RE: INFORMATION REQUEST – COMMUNITY TITLE SUBDIVISION LOT 211 DP1044292 & LOT 1 DP262300, PACIFIC HIGHWAY MOONEE BEACH

The following correspondence provides further detail and clarification of matters raised in the Information Request summary prepared by Coffs Harbour City Council (CHCC) dated November 24, 2009.

IAN MAHER TOWN PLANNING CONSULTANCY
PROPOSED SENIORS LIVING
LOT 211 ON DP1044292, MOONEE BEACH
TYPICAL BIORETENTION TRENCH SECTION

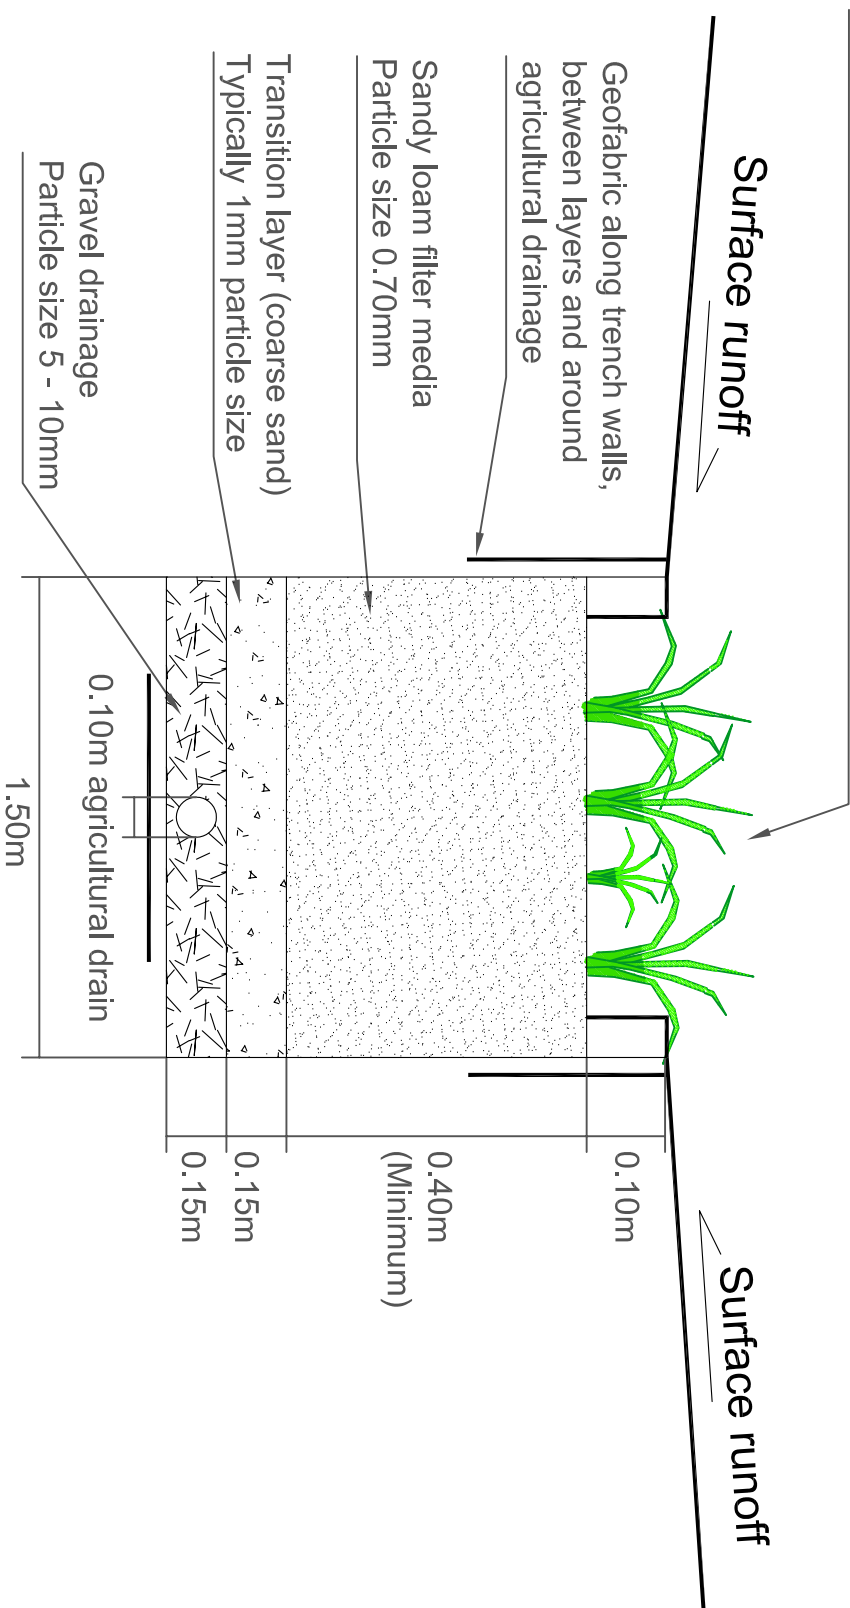
- *The stormwater management plan proposes a bio-retention swale within the local east west road reserve. This is unacceptable and should be contained within the Community property. If it can't be then an alternative treatment measure should be provided.*

It is understood from discussions with CHCC that future upgrades are planned for the proposed road running east-west on the southern boundary of the development footprint. CHCC has concerns that the bio-retention trench may need to be removed to accommodate the proposed future upgrade.

Gilbert & Sutherland have discussed this issue with Geoff Smyth Consulting (the consultant responsible for managing this DA) and have been advised to defer any changes to the current stormwater treatment design and layout until this issue has been resolved. We understand others will be discussing the suitability of the road upgrade with Council. If necessary we can provide further detail regarding stormwater management on settlement of this issue.

IAN MAHER TOWN PLANNING CONSULTANCY
PROPOSED SENIORS LIVING
LOT 211 on DP1044292, MOONEE BEACH
STORMWATER QUALITY TREATMENT

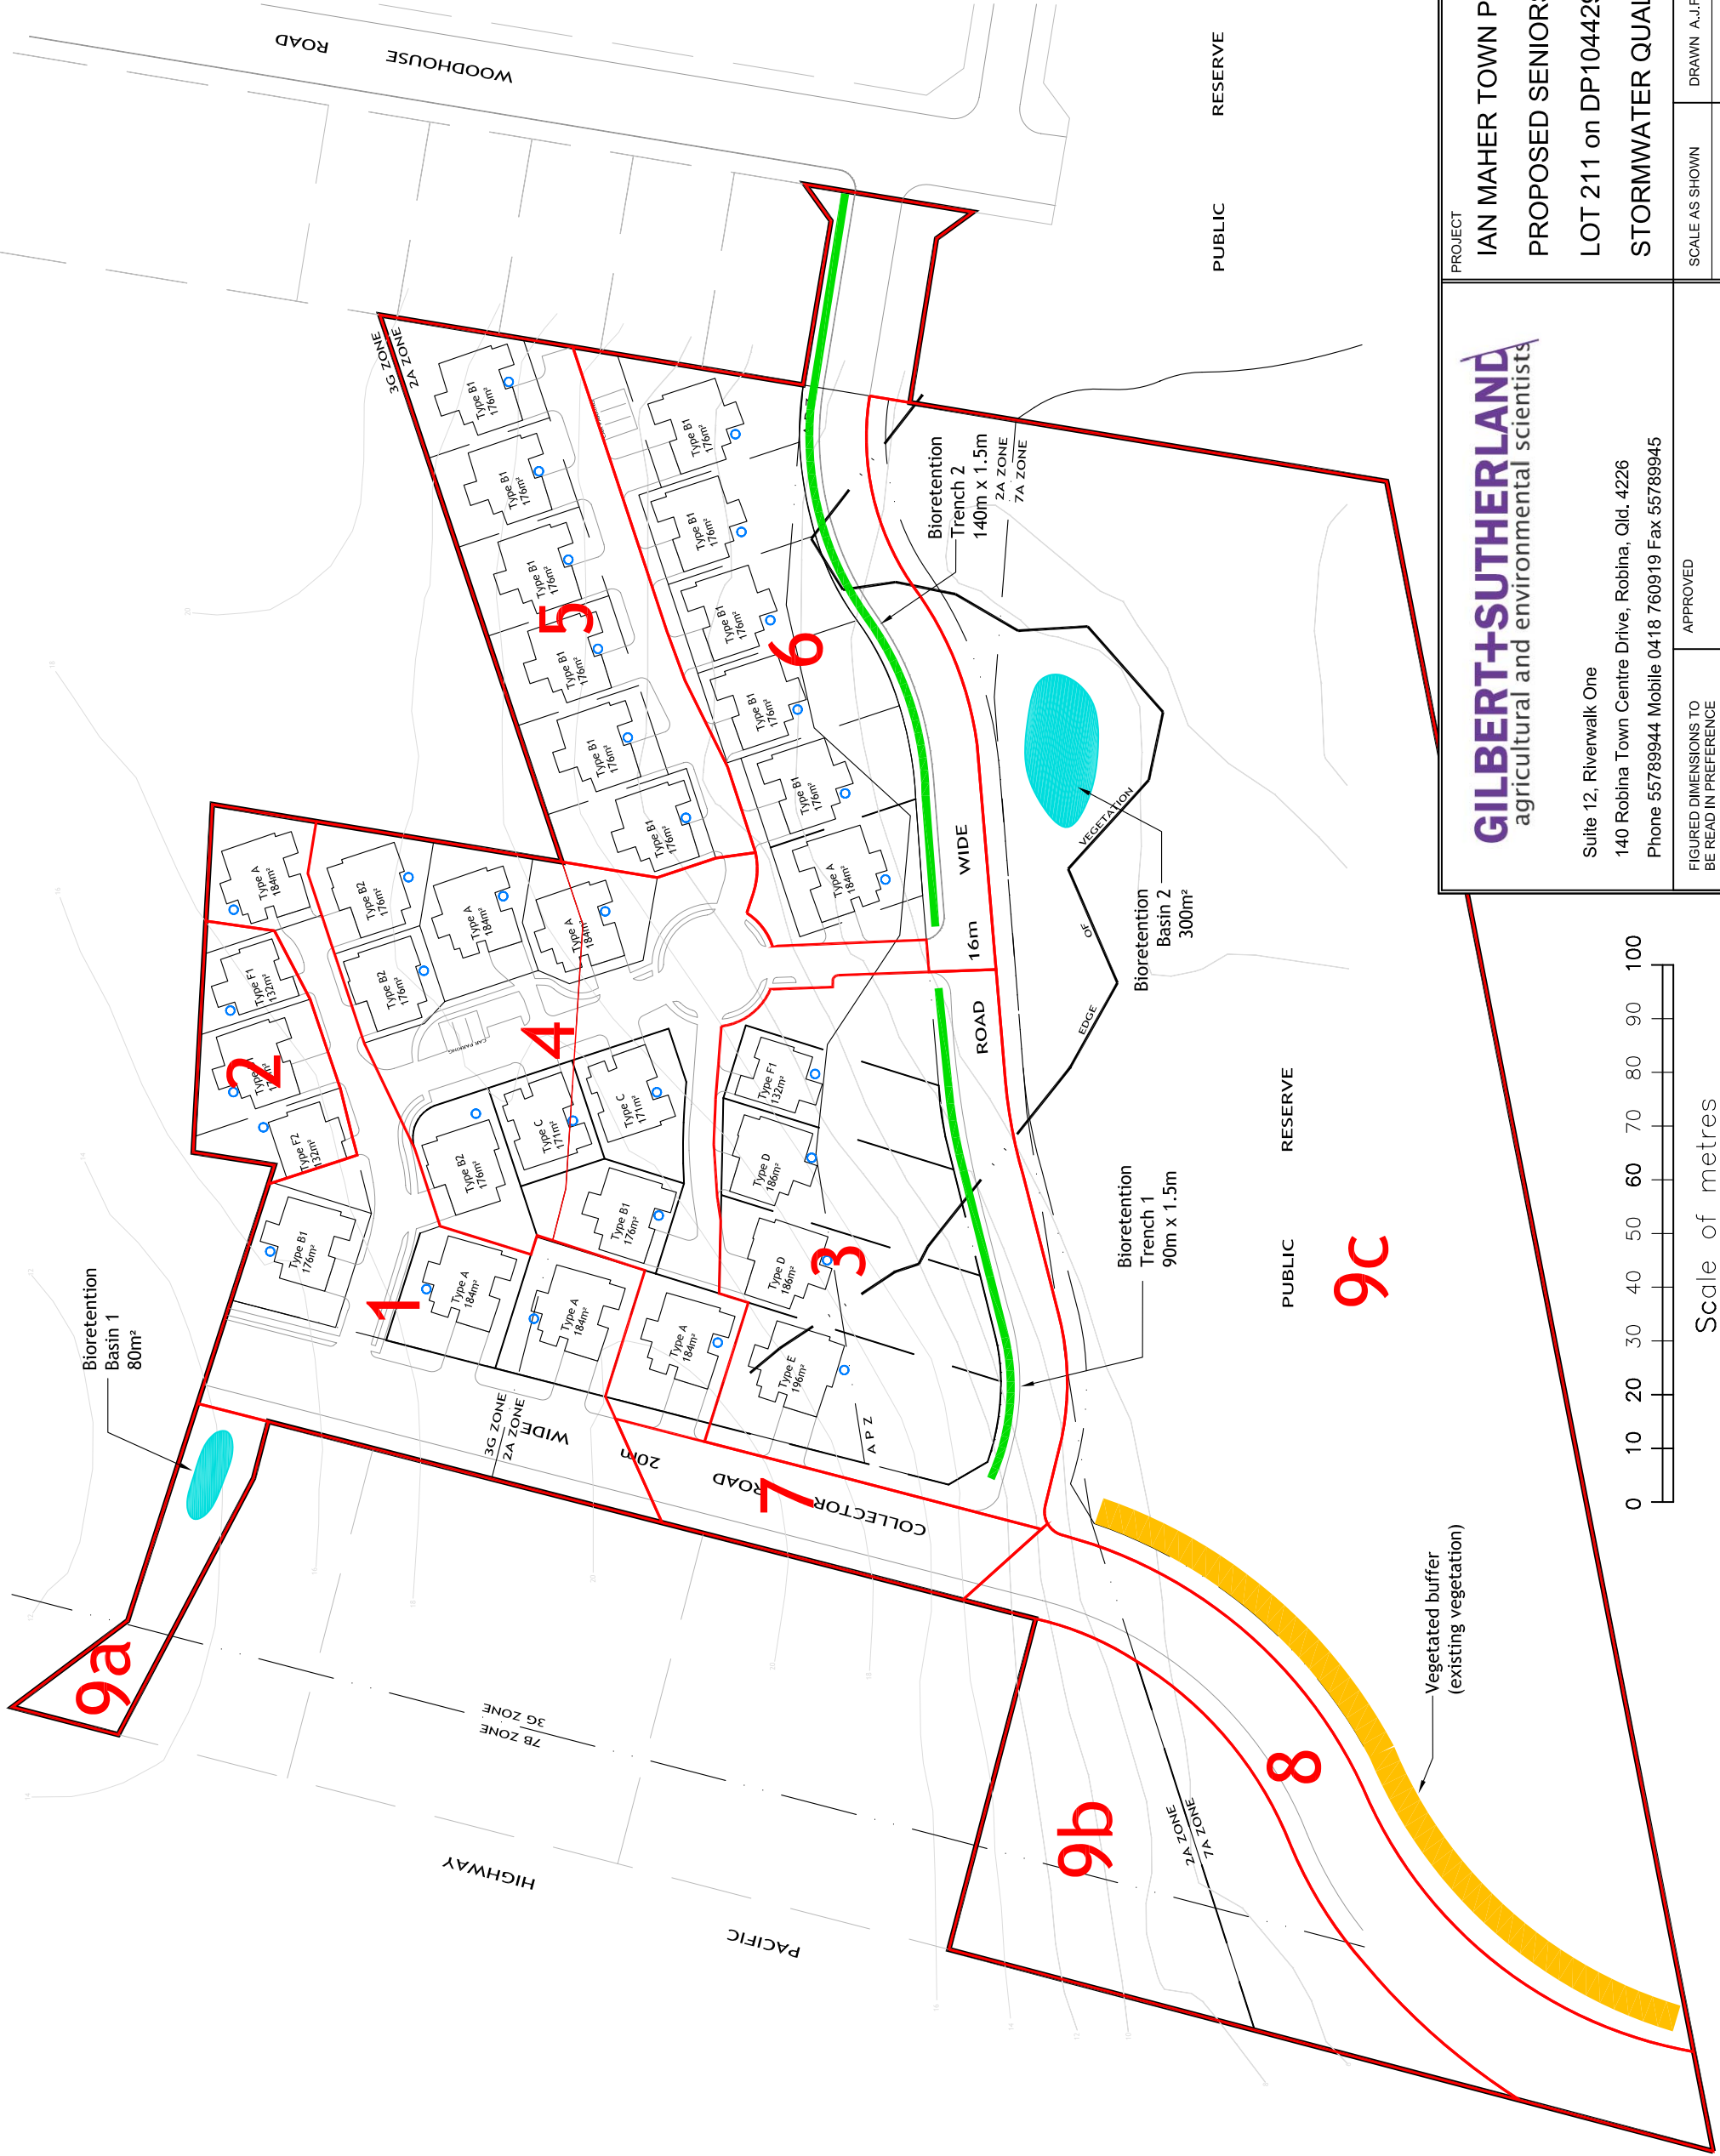
- *The EA does not include a Stormwater Management Plan.*

- *There needs to be a discussion on the types of erosion and sediment control measures proposed, and how they will be implemented.*

A Stormwater Management Plan (SWMP) was included in the EA. The SWMP was included as Attachment 1 of the report titled '*Stormwater Assessment and management plan, proposed Seniors Living, Lot 211 on DP1044292, Moonee Beach, NSW*' prepared by Gilbert & Sutherland June 2007.

The Stormwater Management Plan includes a discussion of requirements for installation of erosion and sediment control measures onsite. This discussion includes a specific table (Table 2.3) dedicated to construction phase erosion and sediment control management.

Additionally, the SWMP contains the commitment that prior to commencement of construction in any stage of the development, that detailed erosion and sediment control plans would be prepared and submitted to CHCC for approval.
